DELEGATED DECISION TO DETERMINE PLANNING APPLICATIONS

Reference No: 2021/62/90448/W

Site Address: 15, Moor Royd, Honley, Holmfirth, HD9 6ES

Description: Erection of two storey side extension and dormer windows to front and rear

DRG No. TC/03 SCALE 1:100 @ A2

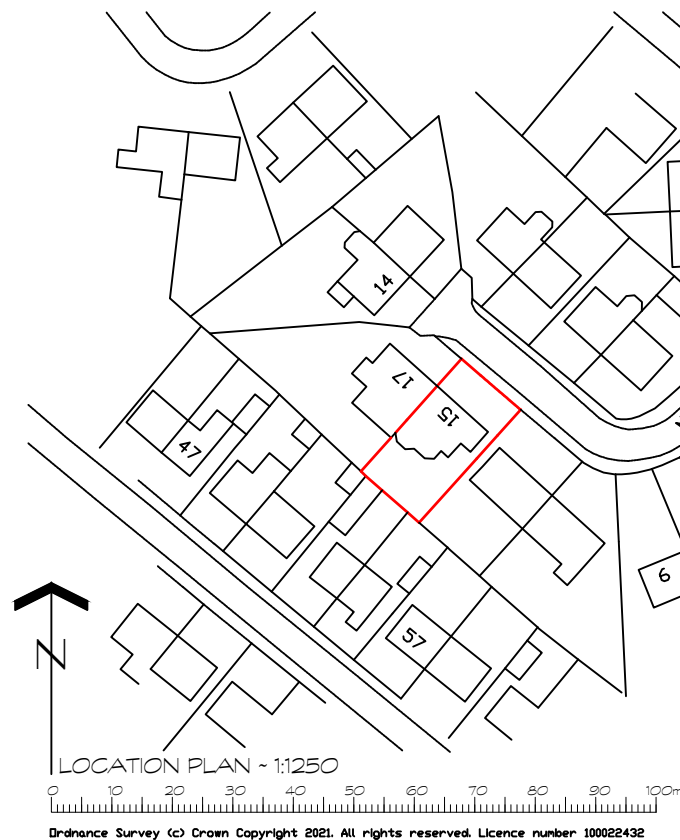
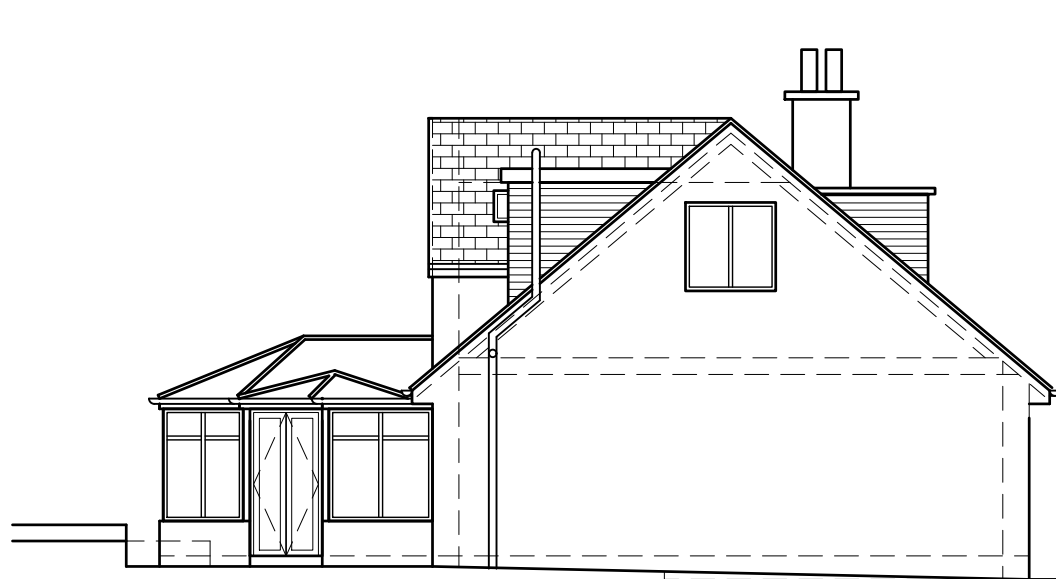
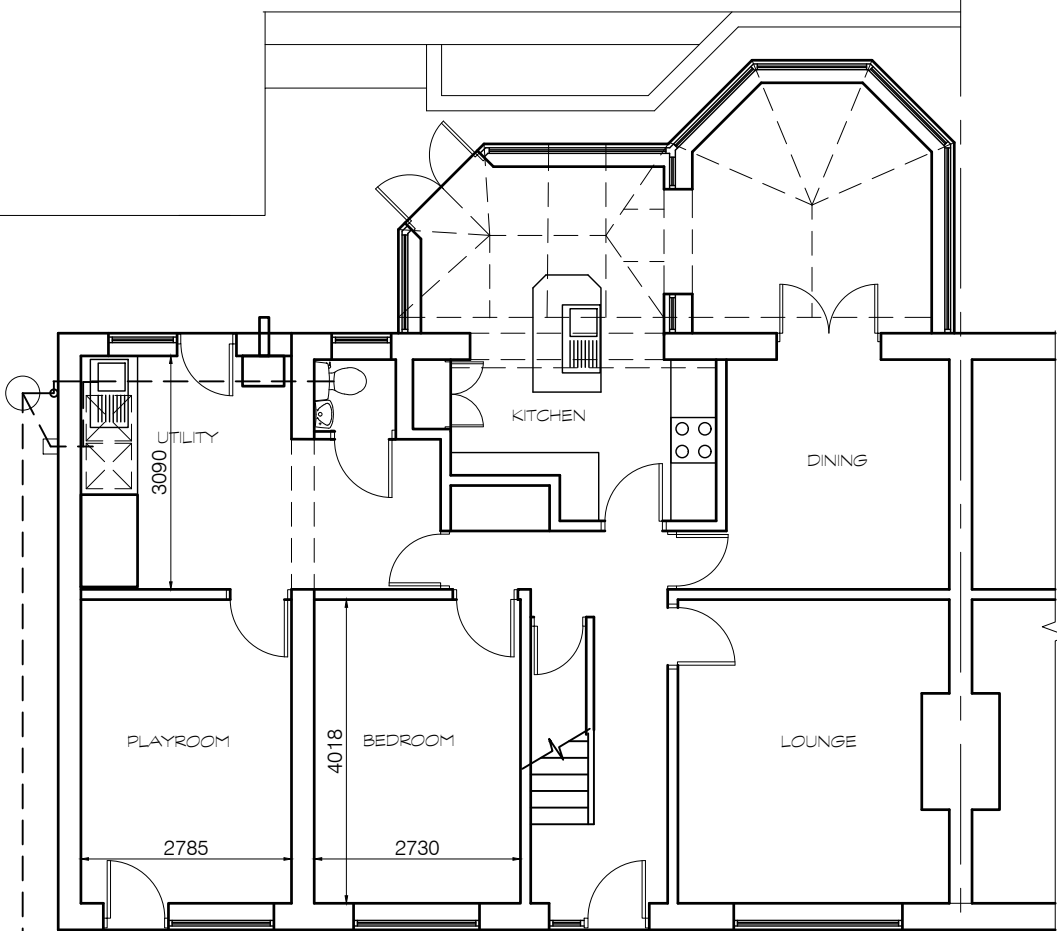
A first floor side facing window was removed from the plans by the applicant's agent following concerns raised by officers in terms of loss of privacy. Details were also later provided of the materials for the proposed dormers after these were requested by officers.

DRG No. TC/03B SCALE 1:100 @ A2

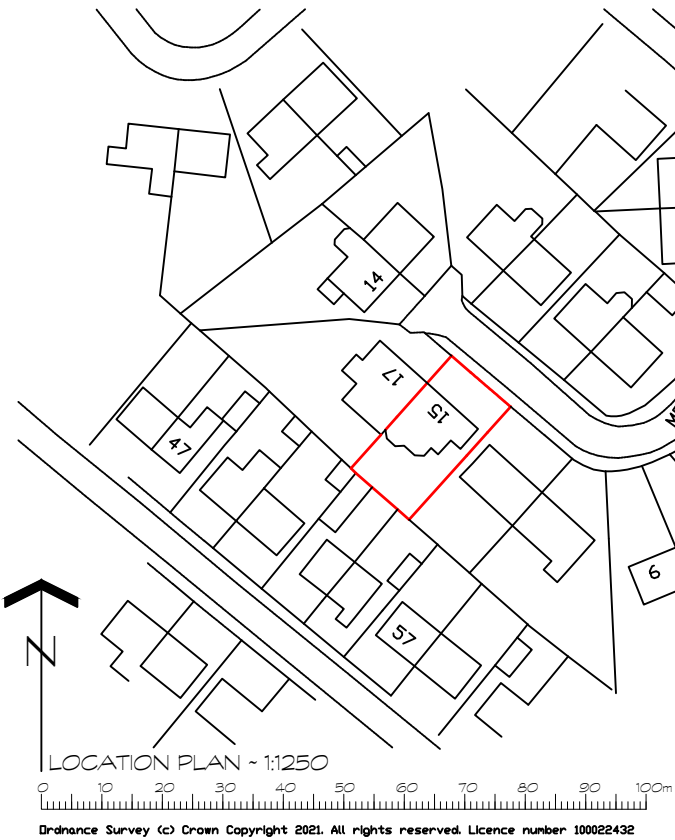
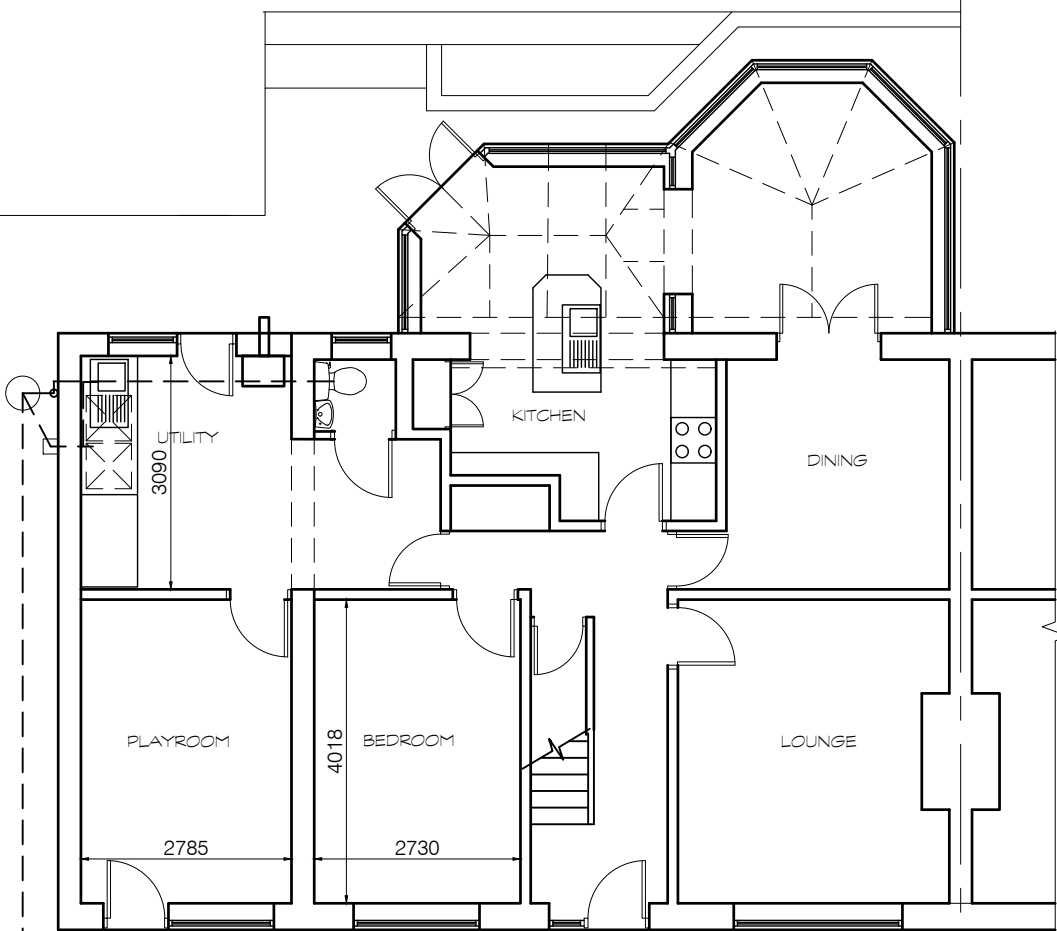
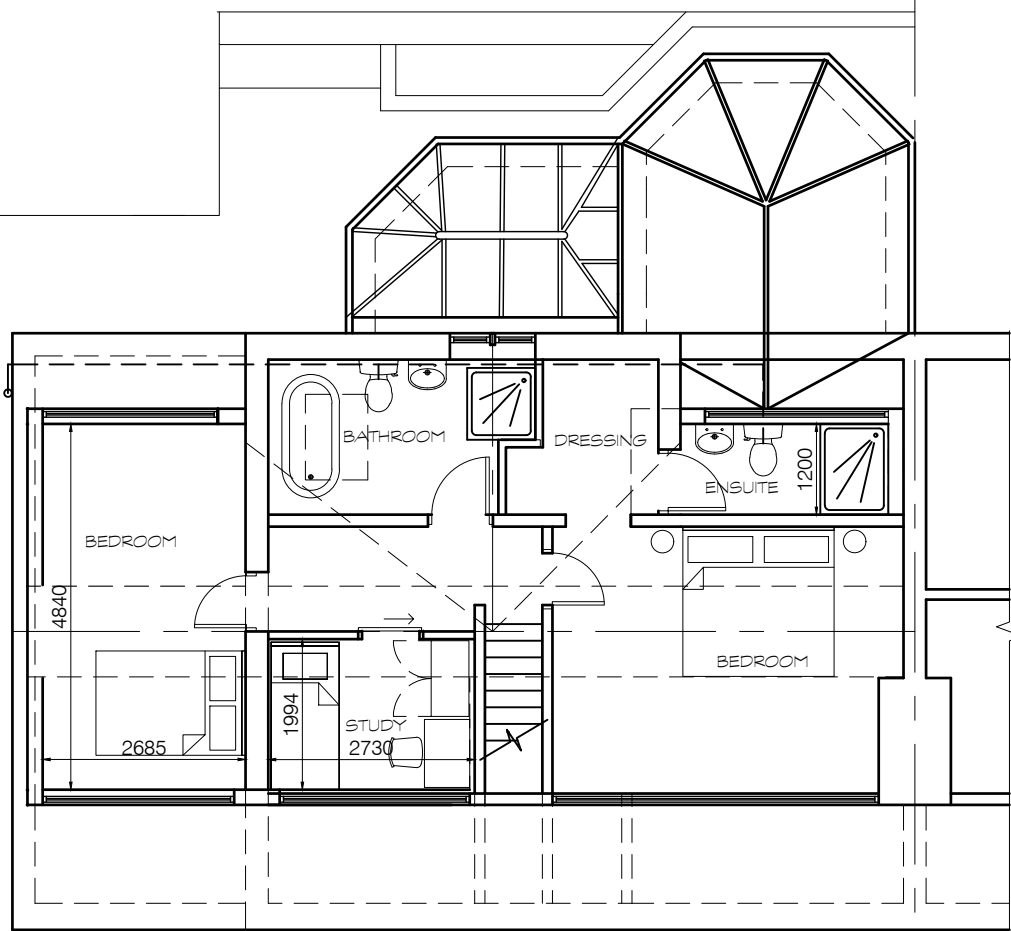
The proposed 1 ½ storey extension to the side would be flush with the front and rear walls of the main body of the dwelling, and would also be flush with the roof slope of the dwelling. Given this, its relatively modest width and the use of materials to match the existing dwelling, it is considered that the extension would be a compatible addition to the existing dwelling.

In relation to the dormer on the front roofslope, this is acceptable in principle given the presence of dormers on the front roofslope of this dwelling and similar 1 ½ storey dwellings. The proposed front dormer would extend from the existing front dormer, and would be of a similar height, design and form to this and it is considered that this would appear as a sympathetic addition to the existing dwelling.

The proposed box dormers to the rear of the dwelling are considered to be bulky and unfortunate features. However, there are other box dormers to the rear of properties on Moor Royd, and the proposed dormers would not be prominent from the public domain due to their siting to the rear of the dwelling. It is also worth noting that a box dormer to the rear of the existing dwelling could potentially be constructed under permitted development and there are other dormers to the rear of dwellings within the vicinity of the site.

The proposed rear dormers would allow for oblique views in to the rear garden of No's.13 and 17 Moor Royd. It is noted that the only first floor window within the rear of No.15 is obscurely glazed, but it is not conditioned that this should be obscurely glazed and fixed shut so could be changed to clear glazing which would allow for similar views as those from the proposed dormers. In addition, a dormer with clear glazing could potentially be installed on the rear roofslope of the existing dwelling without planning permission (under Part B, Class 1, Schedule 2 of the GPDO). A first floor side facing window within No.15 also overlooks the rear garden of No.13. It is therefore considered that the proposed rear dormers would not cause undue harm to No's.13 and 17 in terms of loss of privacy or overlooking

4. The external wall materials of the extended front dormer window hereby approved shall in all respects match those in the construction of the existing front dormer.
